CUMBERLAND
CITY COUNCIL

Ref: OA2021/0006

Subject: Request for comments-State Significant Development (SSD)
Application No: OA2021/0006
Property: 14 & 16 Kiara Crescent YENNORA NSW 2161
Proposal: Ministerial Consent - Yennora Liquid Waste Treatment Plant (SSD-10407)

Council has reviewed the submitted information and the Response to Submissions (RTS), and requests that the following matters be addressed:

EIS Appendix 1: Site Plans, Swept Path Diagrams and Equipment Technical Drawings

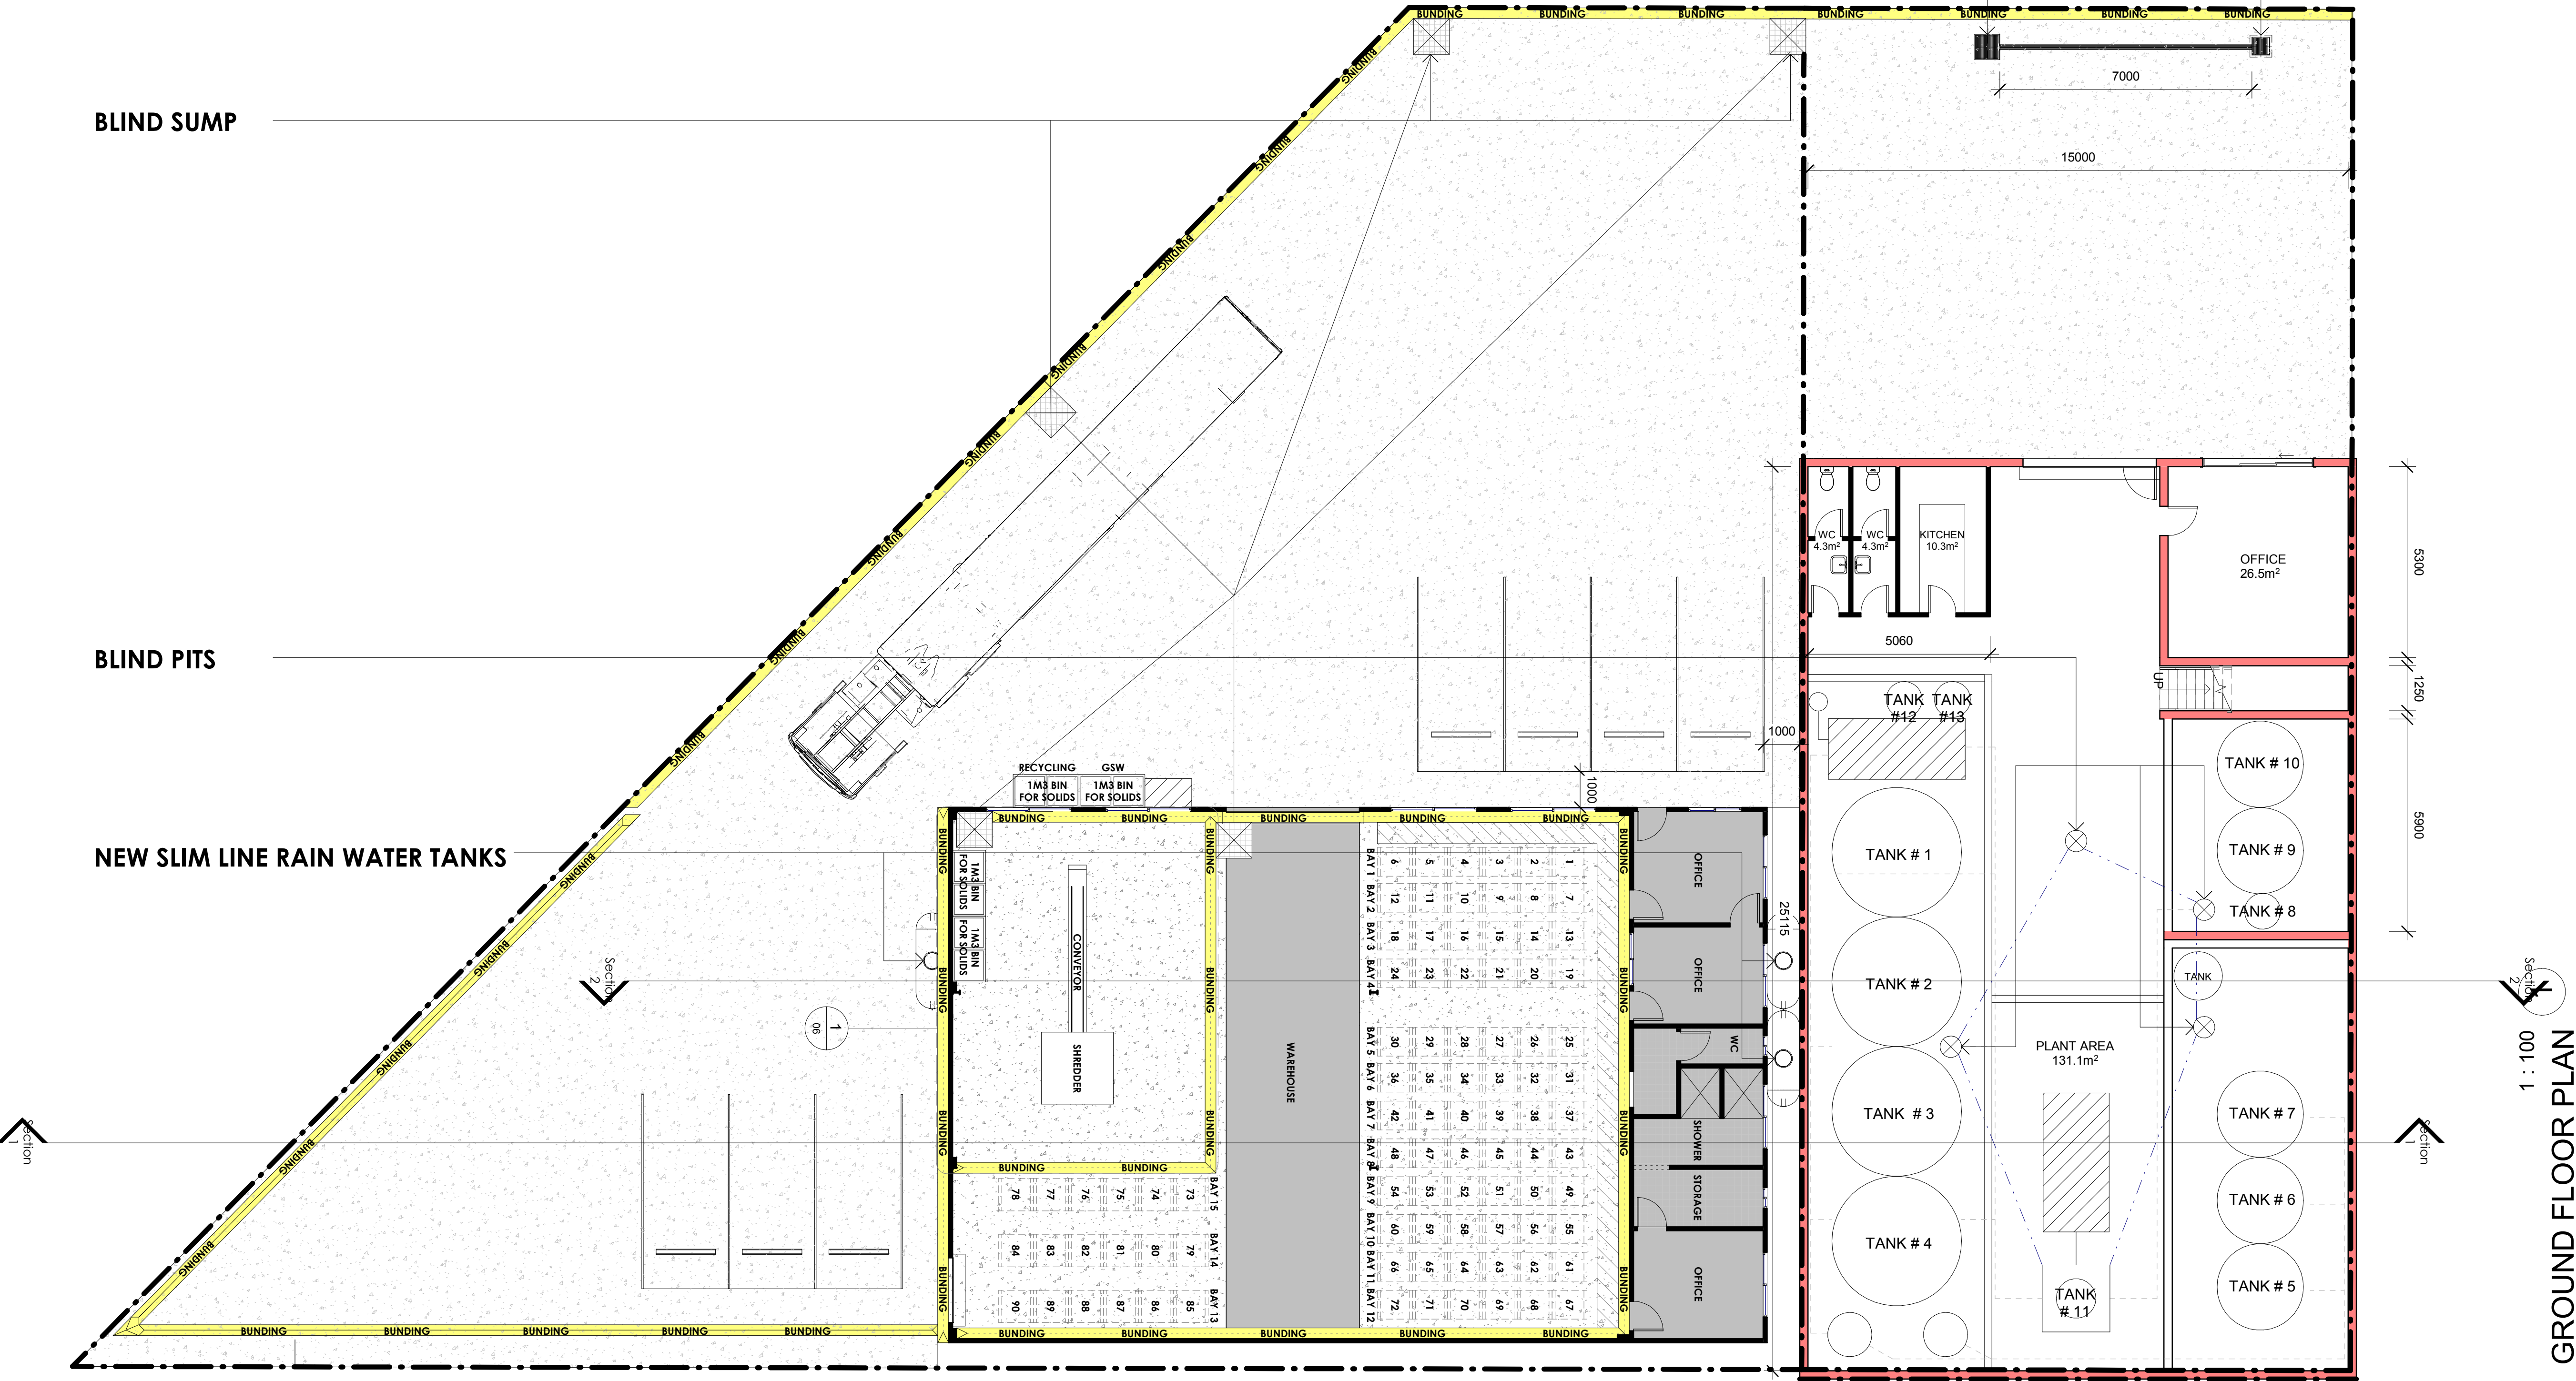
- a) Stormwater plans has not been submitted. It is noted stormwater from the development site will not be discharged to Council's system as per the Environmental Impact Statement (EIS). It appears currently there are two stormwater outlets from the site to street gutter.

As stated in the Response to Submissions (RTS) the proposal shall comply with the requirements as outlined in Section 7.0 (Stormwater Management) under Part "A" of Holroyd DCP 2013.

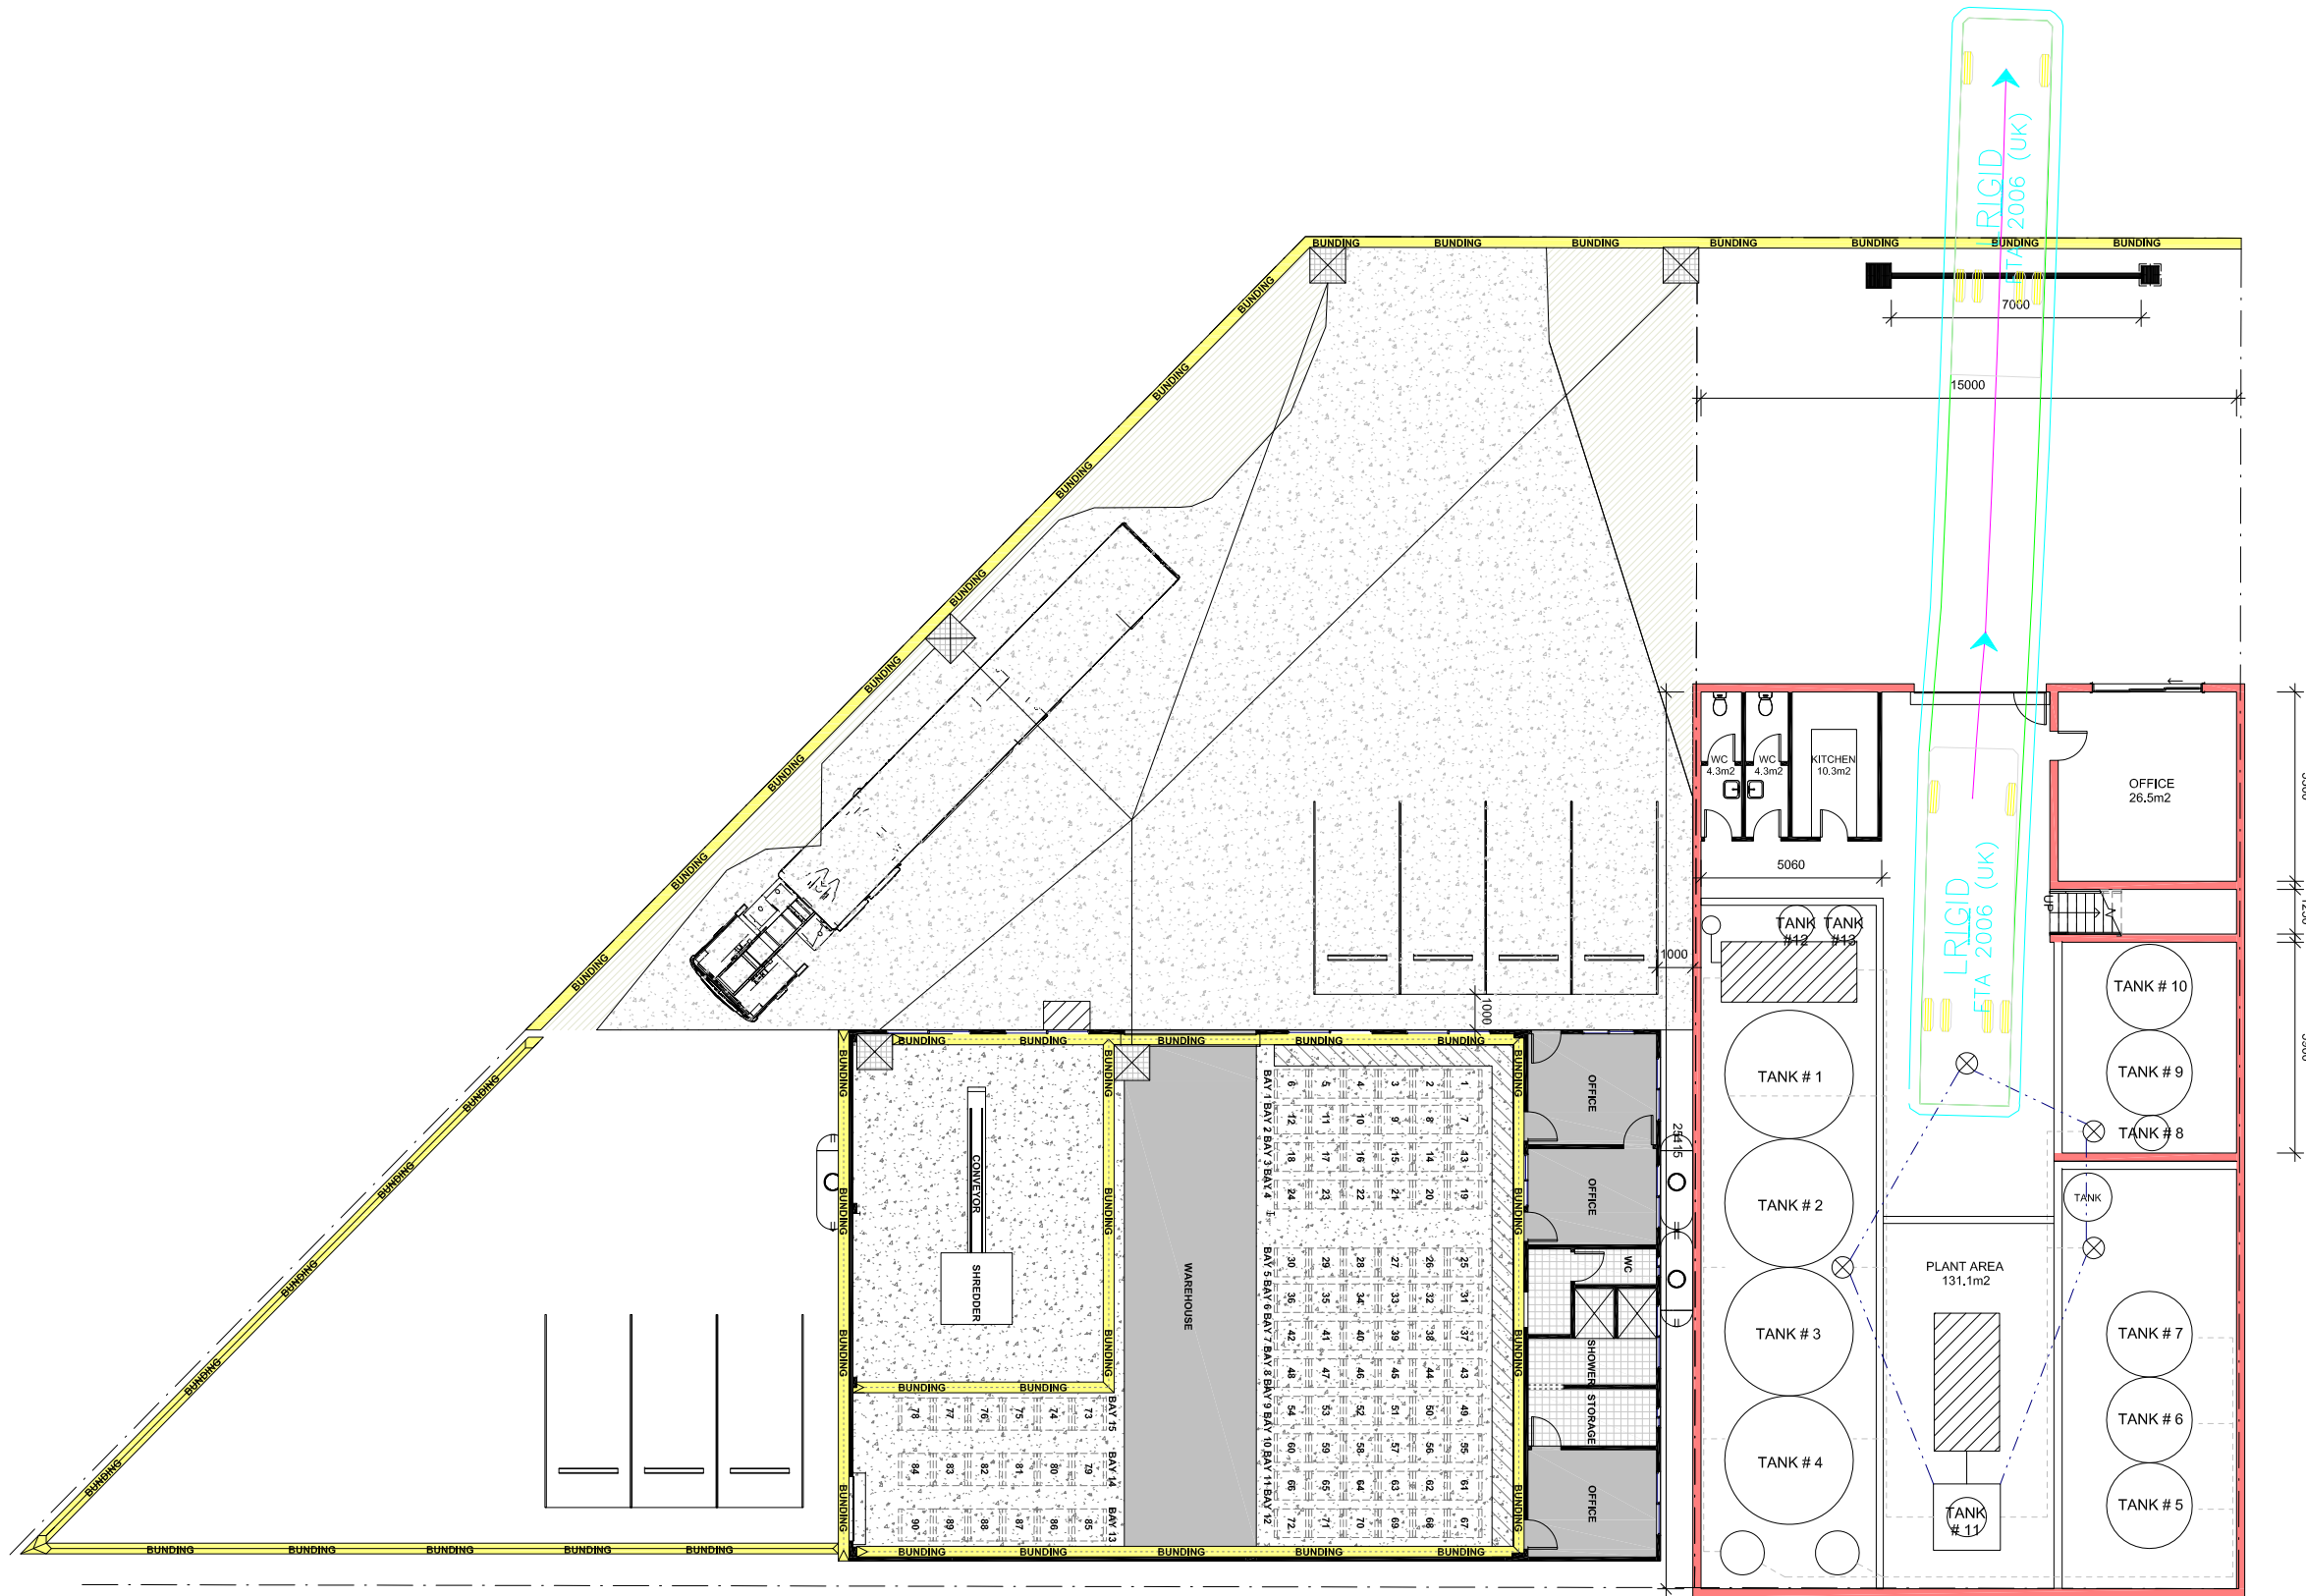
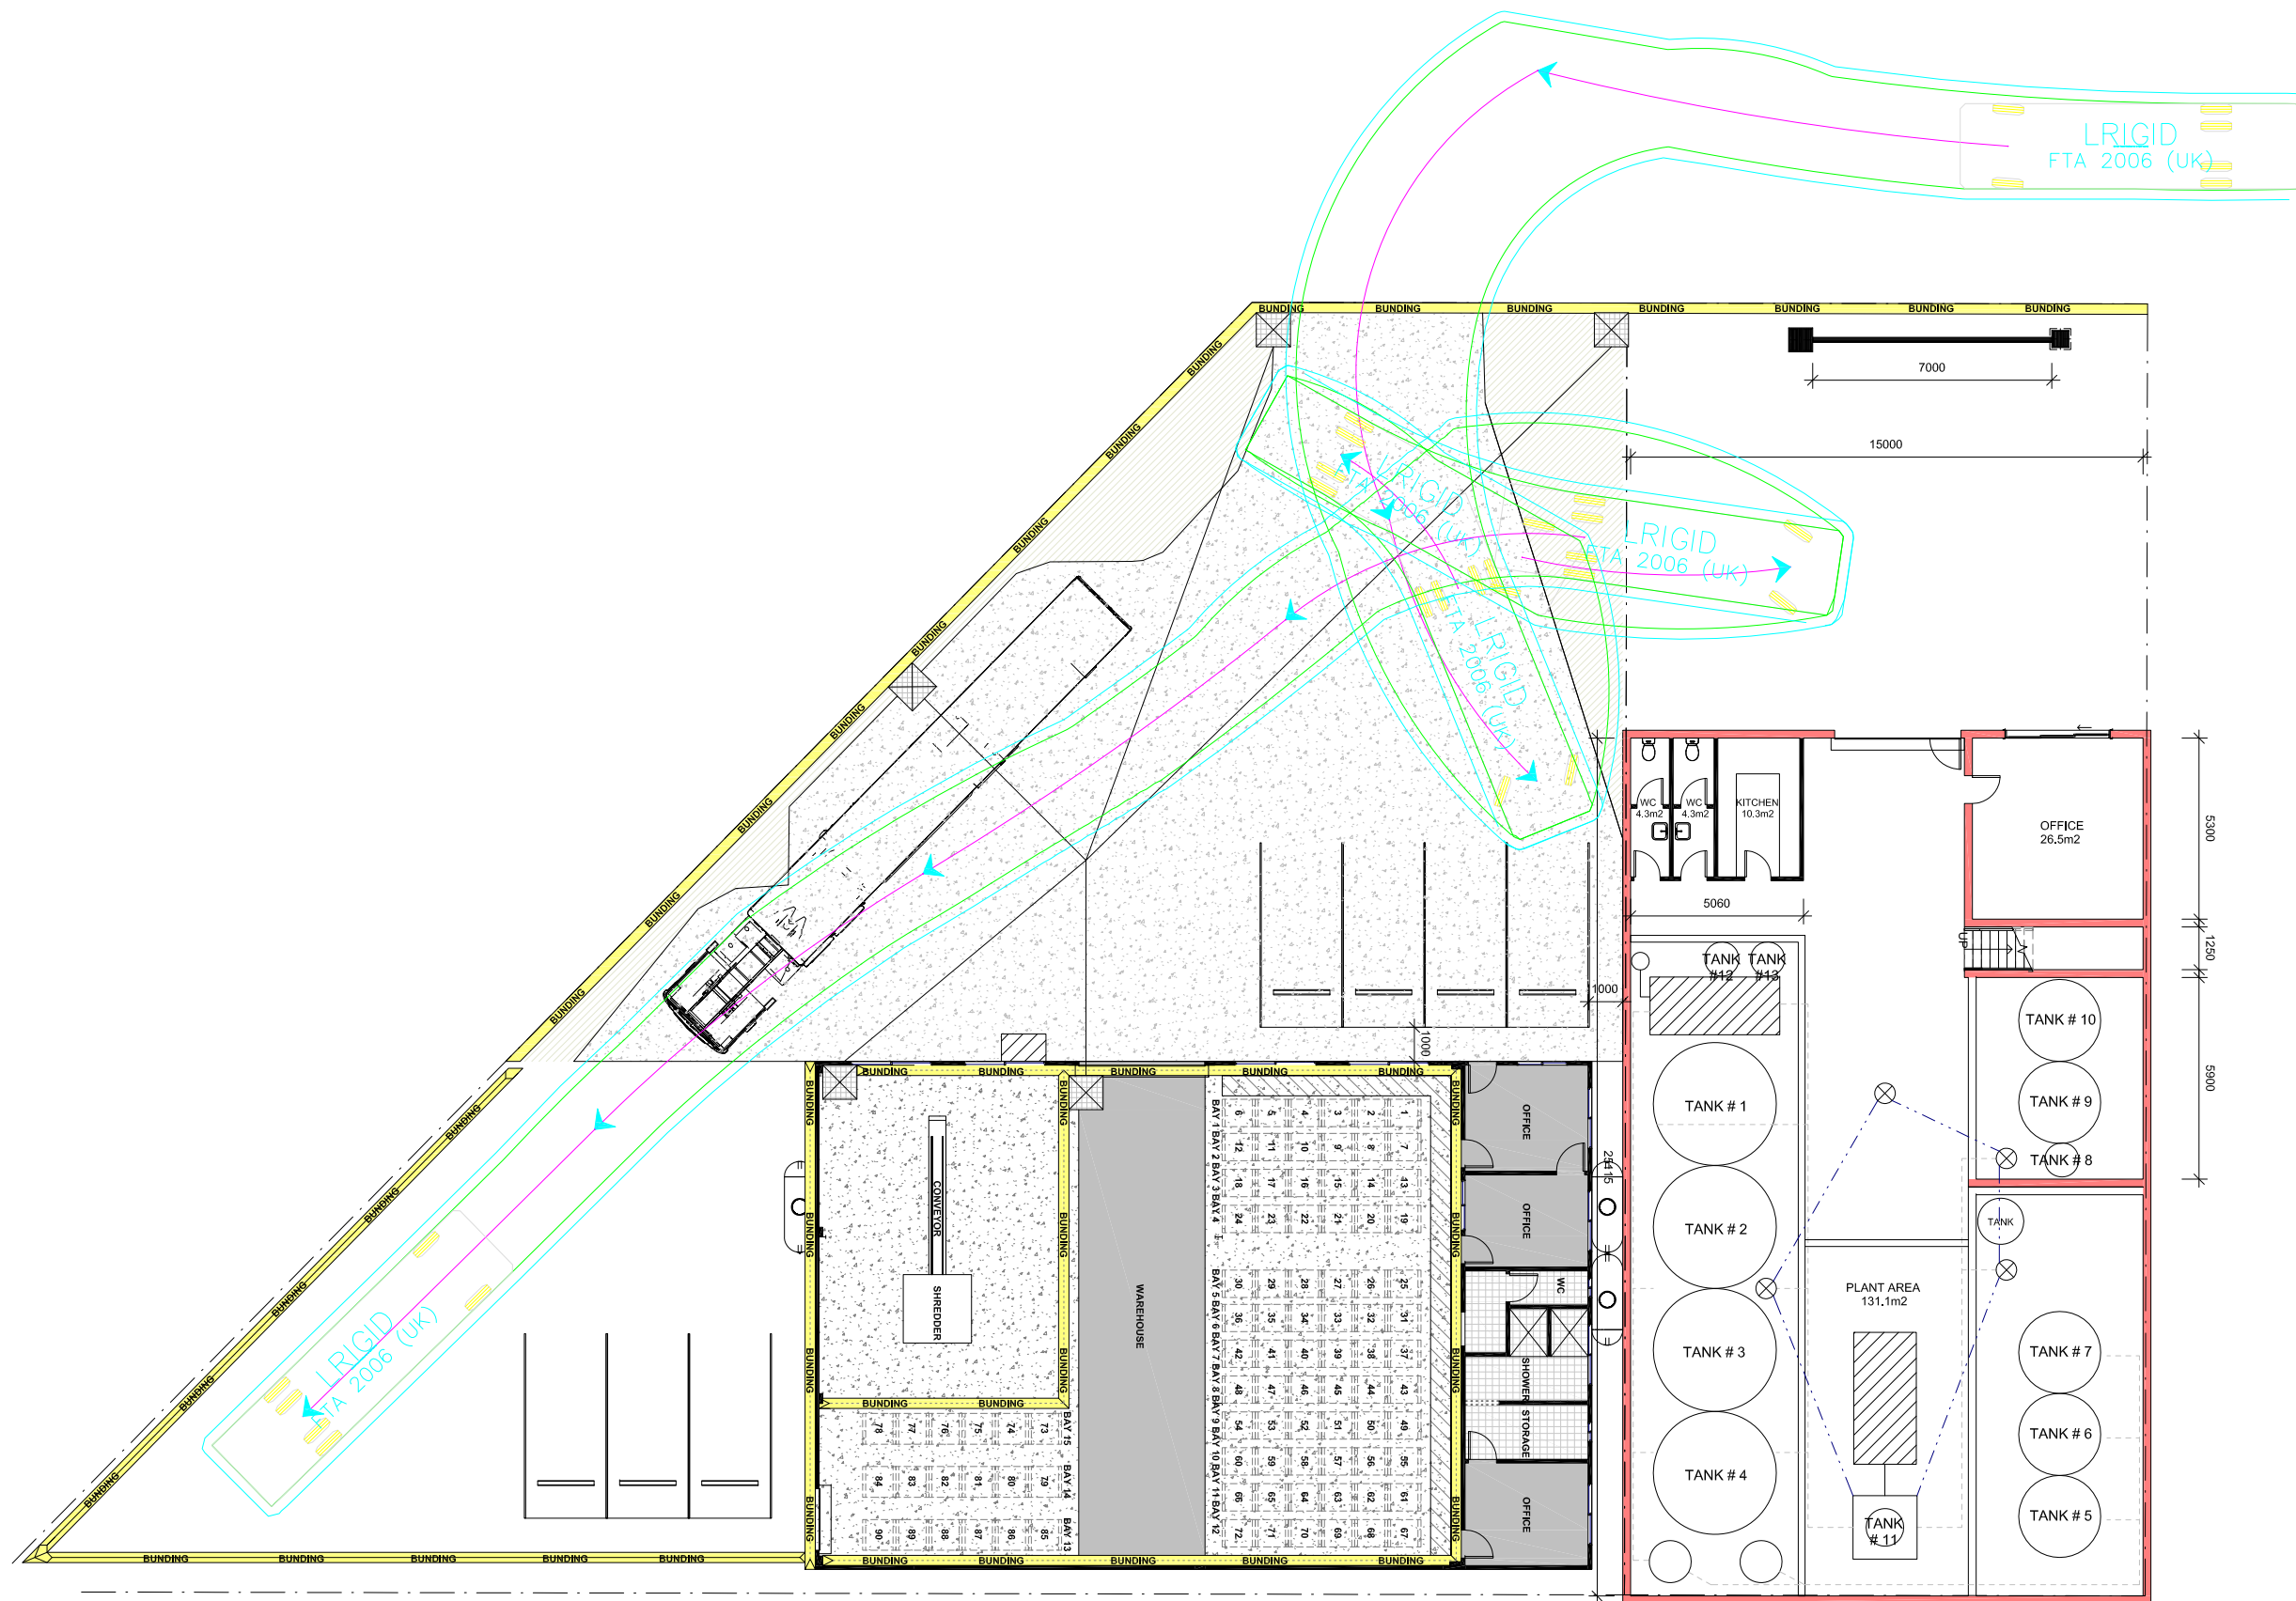
- d) Council will not support the proposed driveway widening. Driveways are provided for the site access only. All the turning manoeuvring shall be provided within the site. A separate approval shall be obtained from Council's Engineering Section for any modification to the driveway.

- e) Reverse manoeuvring in Council's land is not permitted. It will compromise the safety. Vehicles should enter and leave the site in a forward direction.

- f) Proposed 4 point turn truck manoeuvring movement is not acceptable. Manoeuvring shall be limited to three point turn. Multiple point turn (more than 3 points) will result in additional time for the turning and manoeuvring thus overlapping with the arrival of another vehicle (truck) and causing obstruction and delay. Enough space must be provided for manoeuvring and turning with the minimum delay.

- i) Parking layout shall comply with Australian standard AS2890.1 and AS2890.6.
- j) All the vehicles shall enter and leave the site in a forward direction.
